PENDLETON PARISH COUNCIL

Planning observation from Pendleton Parish Council

**a) Proposed dwelling with garages, garden and landscaping at Kemple
Barn Whalley Road Pendleton BB7 1PP**

4172-10 A

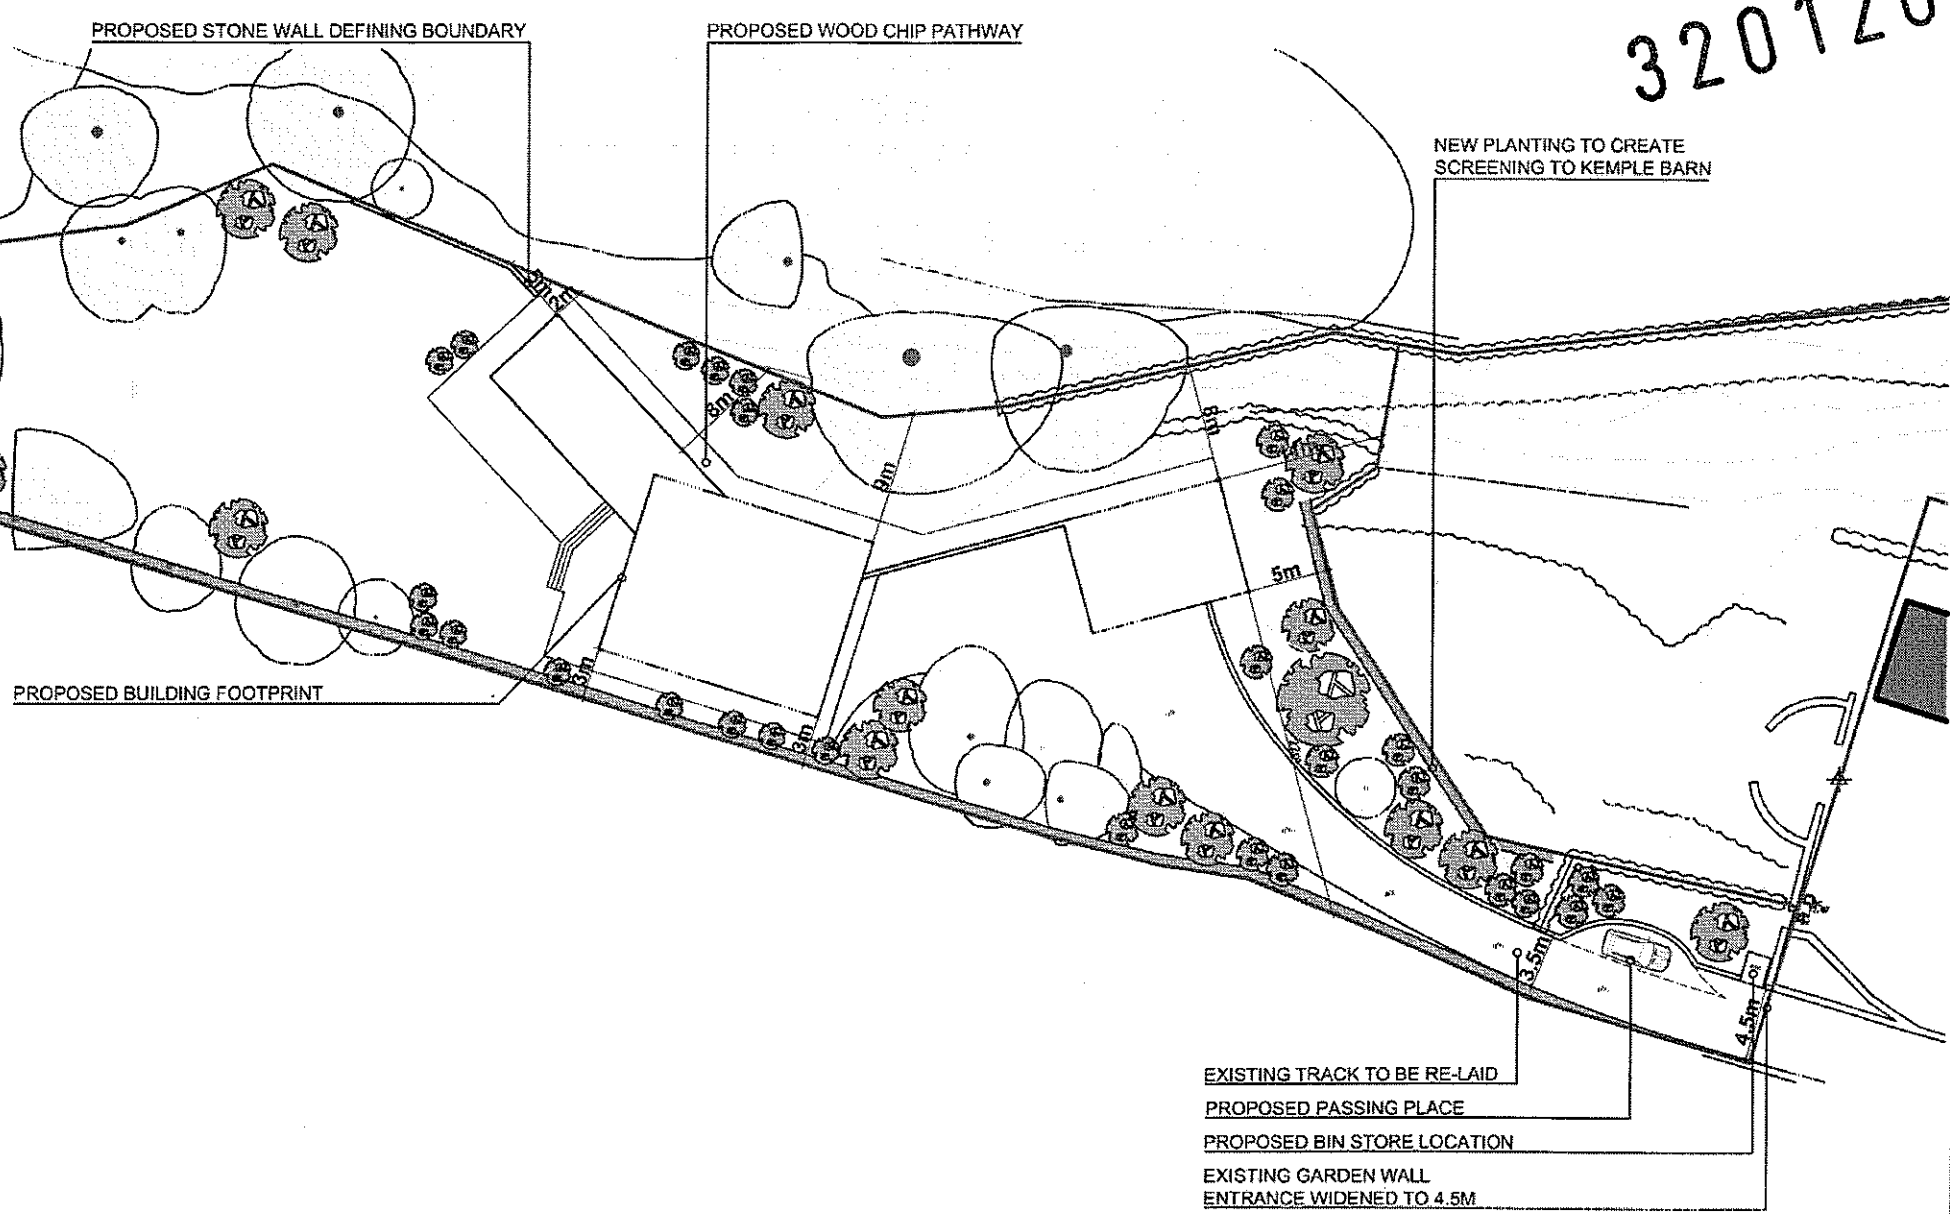
The Parish Council objects to this application as they consider the design of the house to be wrong for the area and object to the loss of trees for the development.
